**Application no: 21/02337/DISC**

**Location:** Proposed Himley Village North West Bicester, Middleton Stoney Road, Bicester, Oxfordshire

## Transport Schedule

**Condition 7 - Phasing Plan - No objection**

Figure 3.1: 2km Walking Catchment

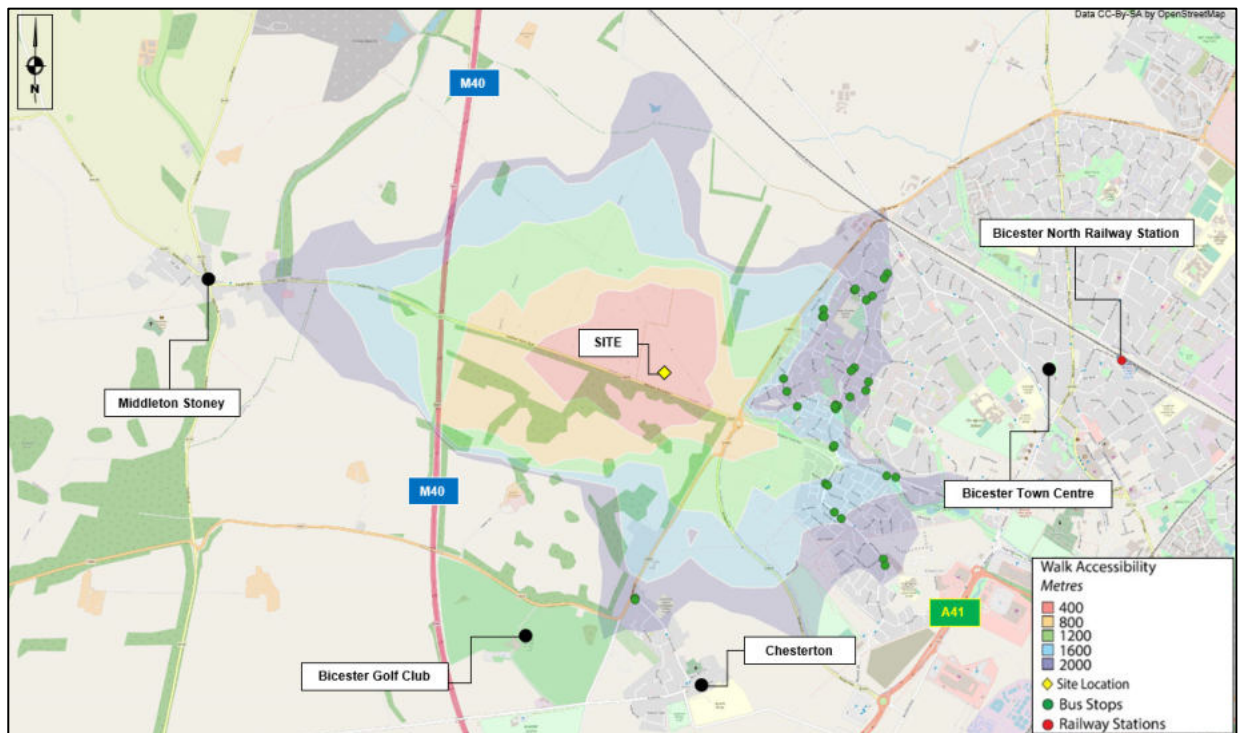
- 3.2.11 and 3.6.2 state that the nearest bus stop is on Wansbeck Drive, 1.0km from the site. This is not the case as a stop has recently been installed on the B4030 at the junction with Empire Road, these are currently served by route 250 which operates hourly on Mondays to Saturdays, however it is hoped that this will be improved to half hourly at peak times and a new hourly Sunday service from later this year 2021.

In addition, service 26 operates to/from a westbound bus stop on Middleton Stoney Road in the vicinity of Ludlow Road, which is closer than the Wansbeck Drive stops.
